Consultation Response from KC Waste Strategy (Refuse & Cleansing)		
PA no. & address: 2020/94285 22-26, Wellington Road, Dewsbury, WF13 1HL		
Proposal: Alterations to office building to form 20 flats and associated office space and laundry (Listed Building within a Conservation Area) – AMENDED GROUND FLOOR AND LAYOUT PLANS		
Date Responded: 12/07/2021	Responding Officer: Carol Oakden	Responding Ref: WPN-20-065R1
NOTES/COMMENTS: The following comments relate to revised drawings 556.22 (--) 007 Layout plan, and 556.22 (--) 002RevF Ground floor plan. The revised plans now show 3 x 1100ltr bins to be stored to the front of the building within a low-level stone-built enclosure with double doors for each bin. This still falls short of the Authority's requirements in that: 1. The proposed storage doesn't accommodate the required number of bins for the size of the development. As previously stated, 6 x 1100ltr bins are required in line with the Authority's fortnightly collection schedule and allowing for recycling facilities to be included. Failure to provide sufficient space will most likely result in extra collections being required. Extra collections will attract a charge from the Autho

PROPOSED GROUND FLOOR PLAN

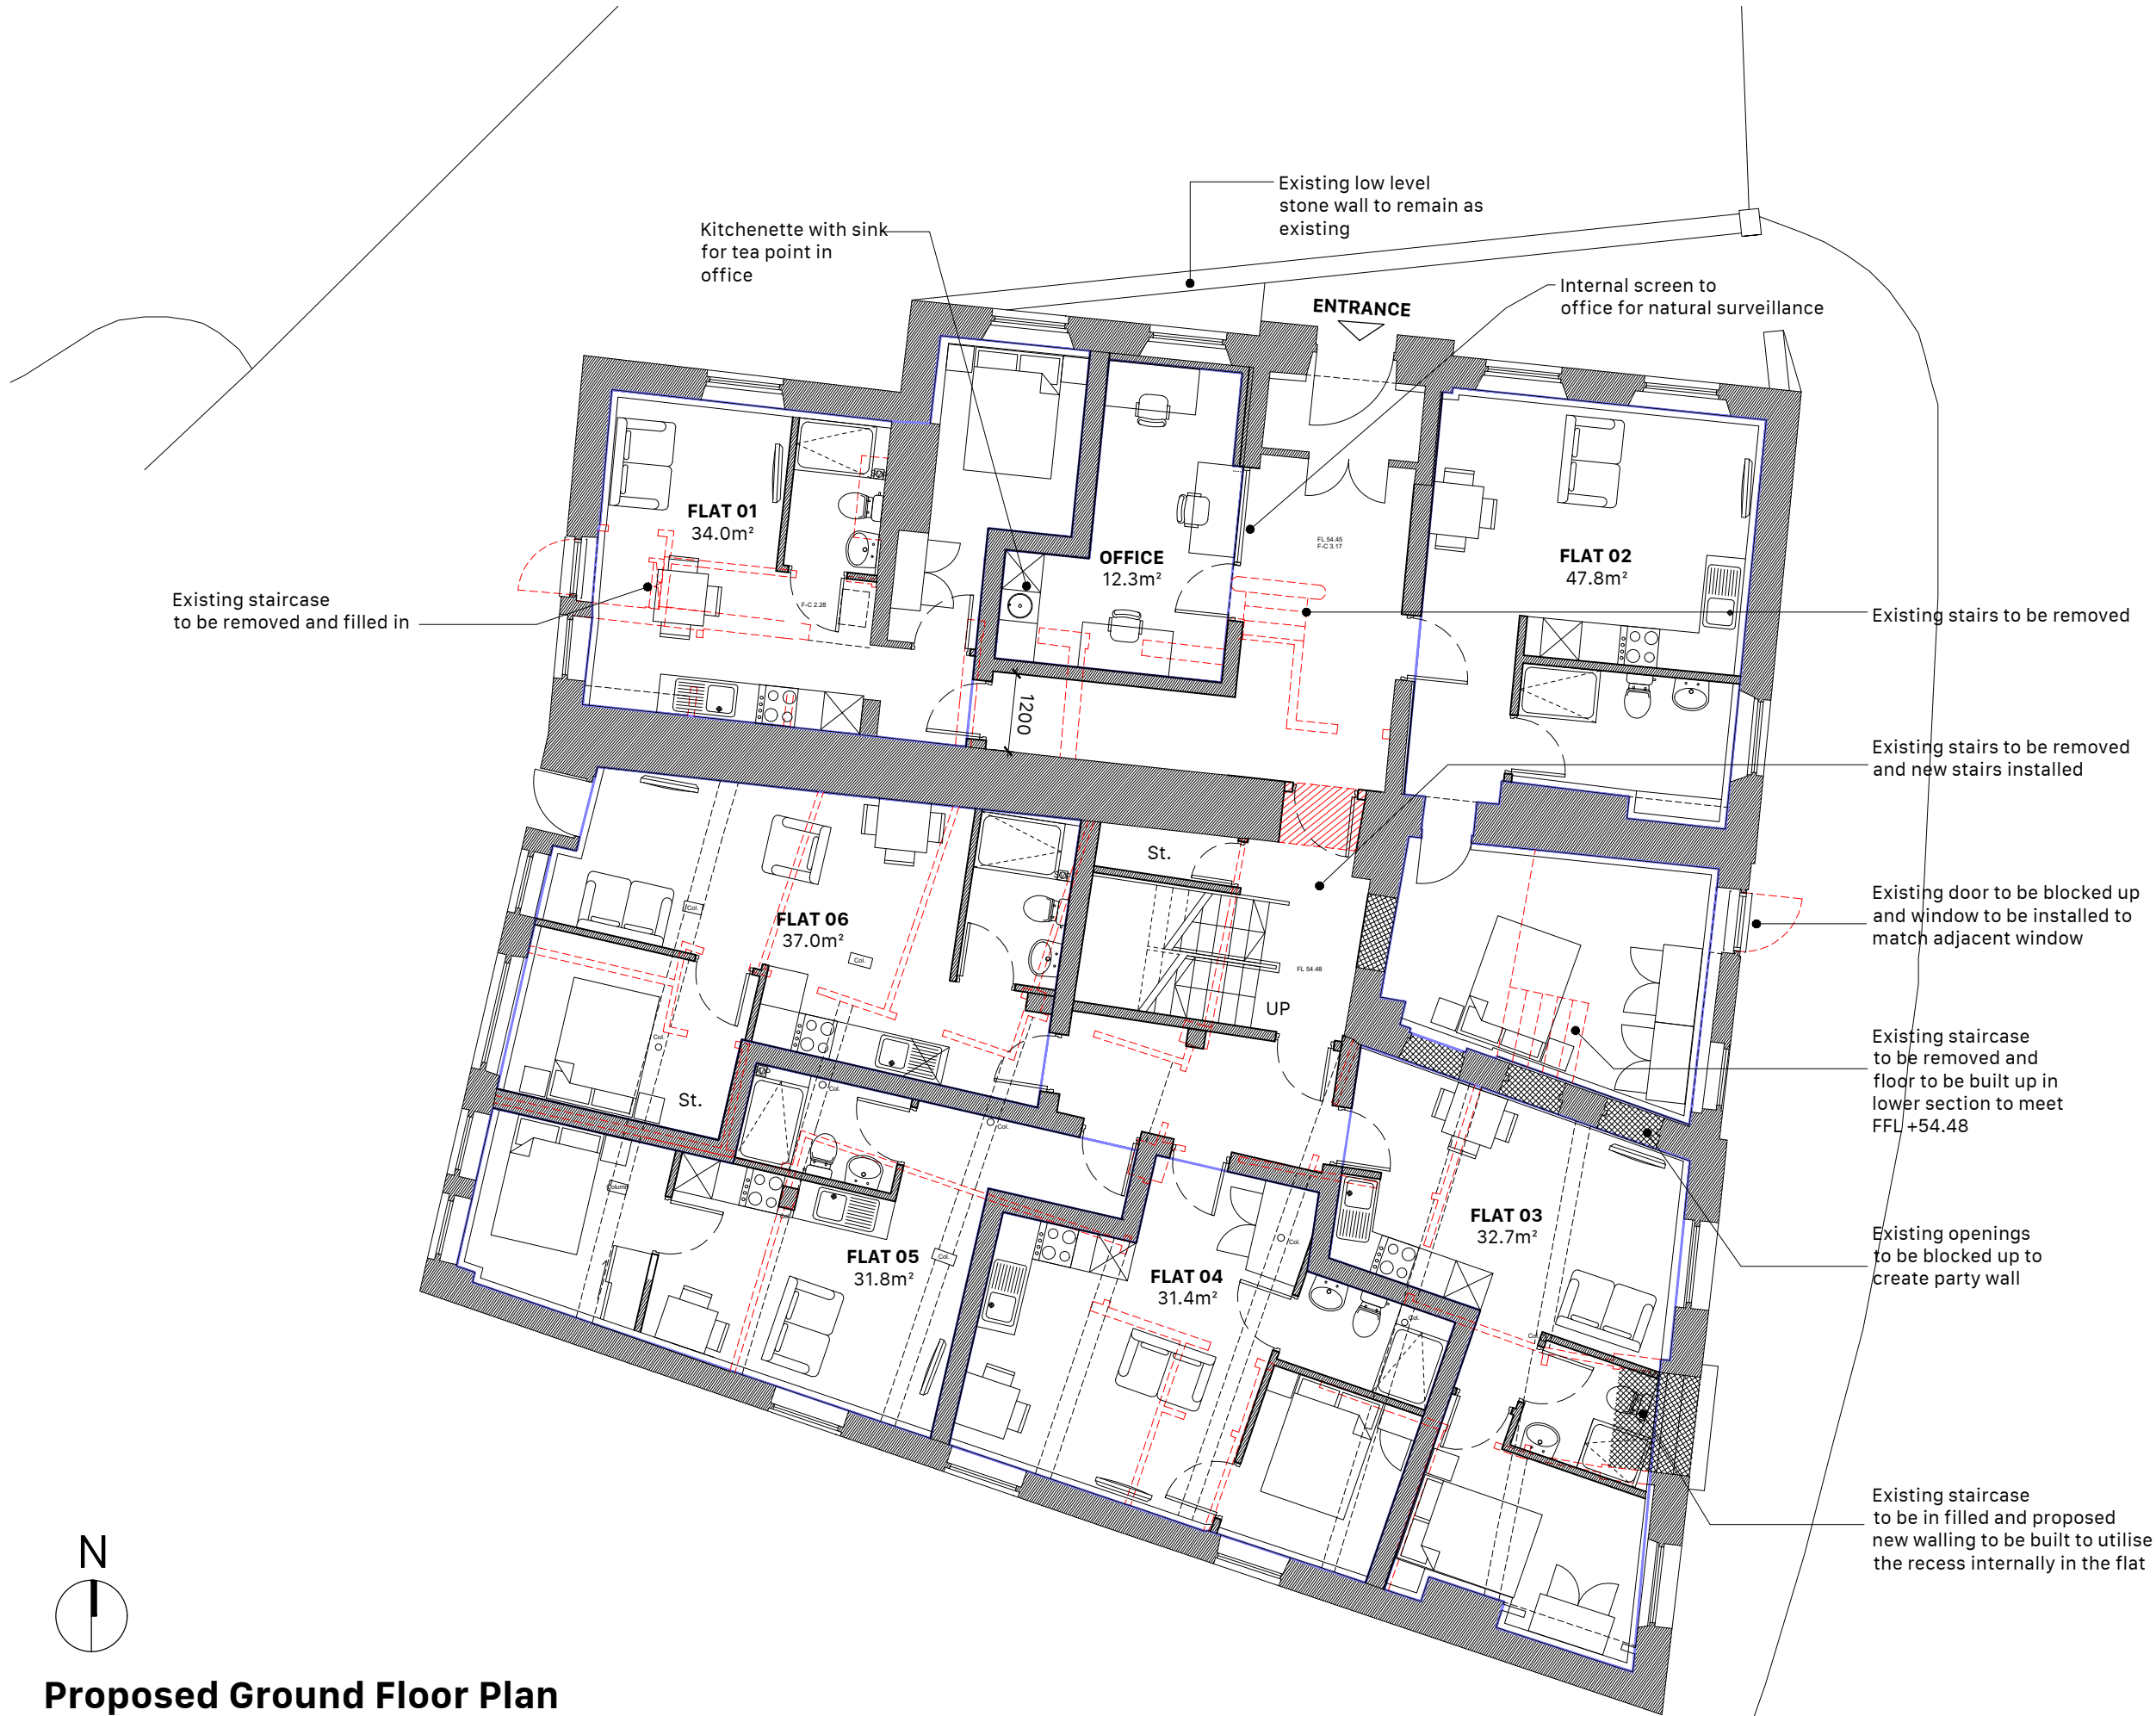
by the Waste Collection Authority as it contravenes the requirements set out in policy LP24 part d (vi) and LP43. Failure to provide suitable waste management facilities would likely result in communal bins being stored on the street, creating an unacceptable visual impact; potential for spillage of waste into the street; potential for unauthorised use/theft/damage to bins, and vermin and odour issues; and a potential fire risk to residents and to surrounding buildings.

Further information is required to demonstrate waste management solutions appropriate to the location and size of the development, addressing the following:

- The proposal is for 20 flats which would generate a waste storage requirement for 10 x 660ltr communal bins (5 for general waste and 5 for recyclable waste) OR 6 x 1100ltr Eurobins (3 for general waste and 3 for recyclables). The smaller bins are preferred as they are more suitable for residential uses and present fewer problems for manoeuvring in and out of smaller spaces.

- If external space can be found for bin storage it must be either 6m away from this or other buildings to mitigate the fire risk, or if this is not possible, storage should be constructed using fire resistant materials and not be located close to doors or windows.

- If internal space can be found for bin storage, it must conform to Building Regulations 2010 Part H6 and British Standard 5906:2005 Waste Management in Buildings Code of Practice, which specify the solutions for fire resistance.

- Wherever bins are located, they will need to be secure, safe and efficient for both residents and collection crews to access; must be on a hard, level surface and be well ventilated with suitable vermin control measures where necessary; must not cause obstruction or be obstructed from being manoeuvred to the nearest adopted highway for collections; and will need to be part of the remit of a management company to manage and maintain.
